Laurie Leader - BP#2014-01013 68 Commercial Street - Plan Review Comments Revised

Attached are the revised drawings for the Maine Wharf Restaurant project. Below you will see your comments (in red) and a description of our revisions made on the drawings.

M.4

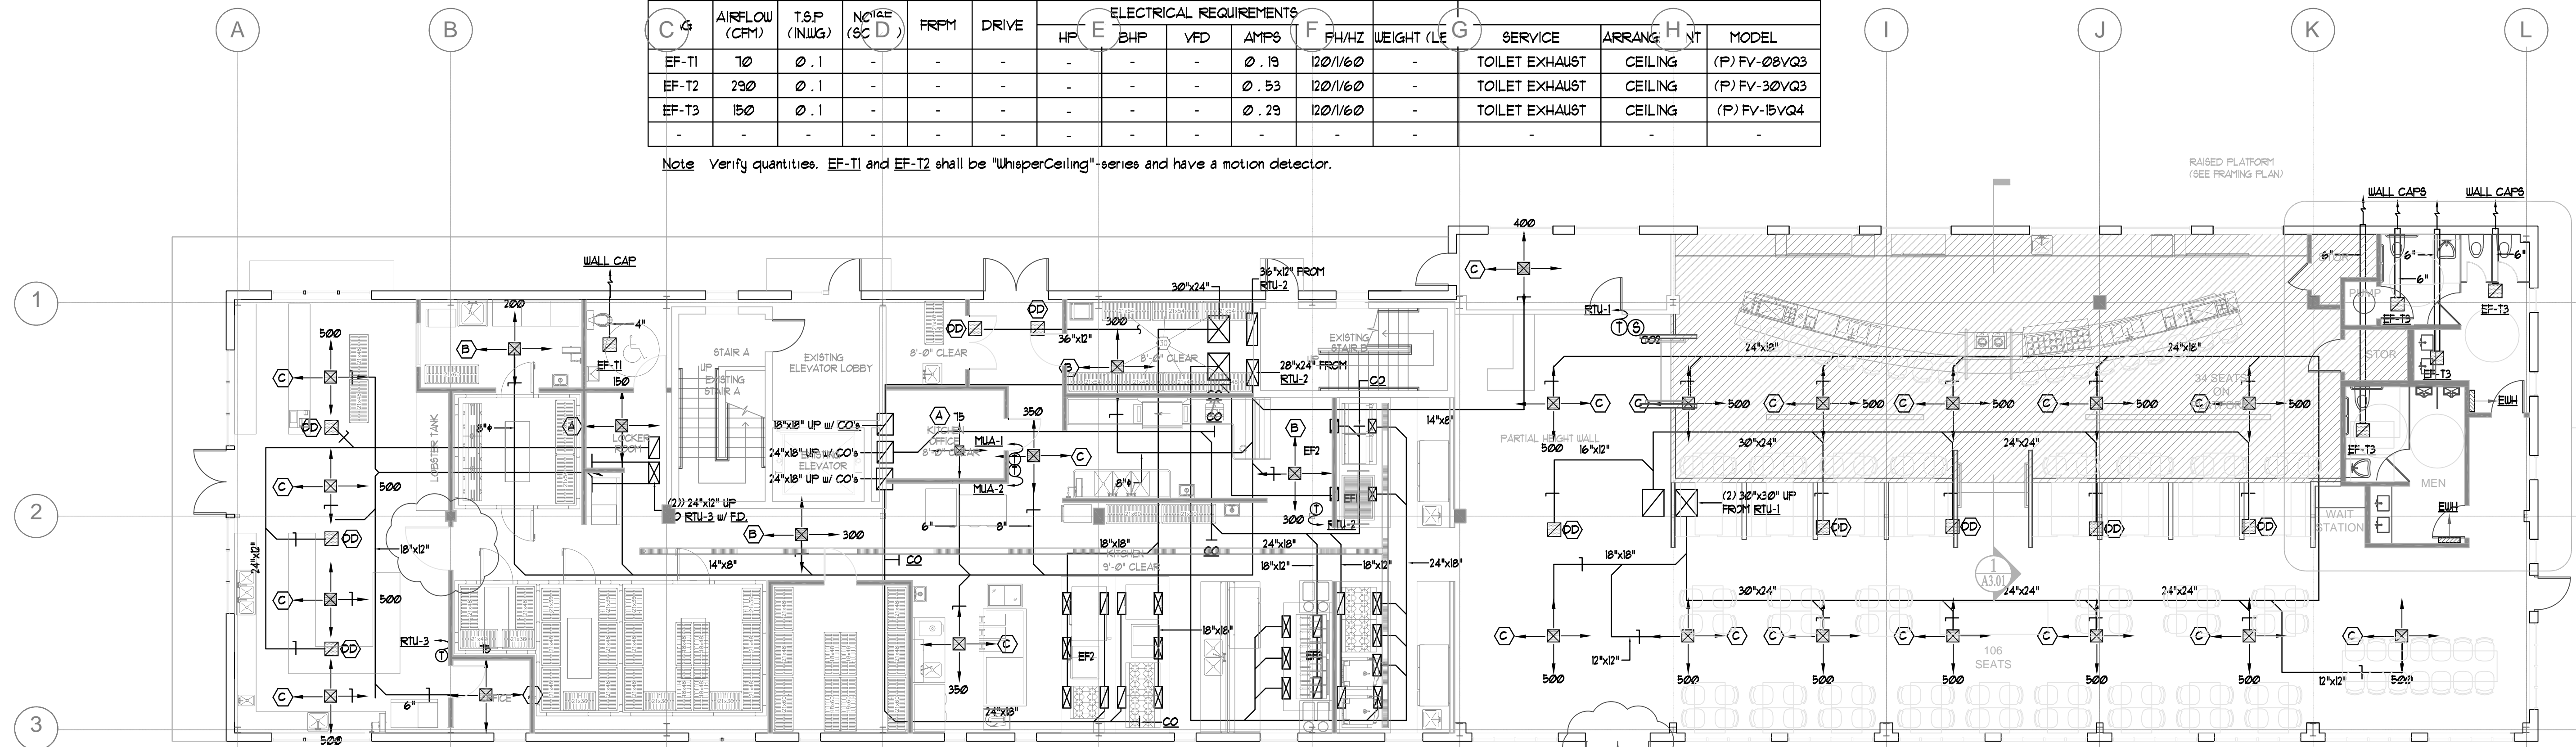
Please provide shaft locations and construction details for hood exhaust including roof termination.

Attached are Mechanical Plans M4, M5, and M6 providing the shaft locations. Also attached is drawing MSK-1 providing a detail for the hood exhaust.
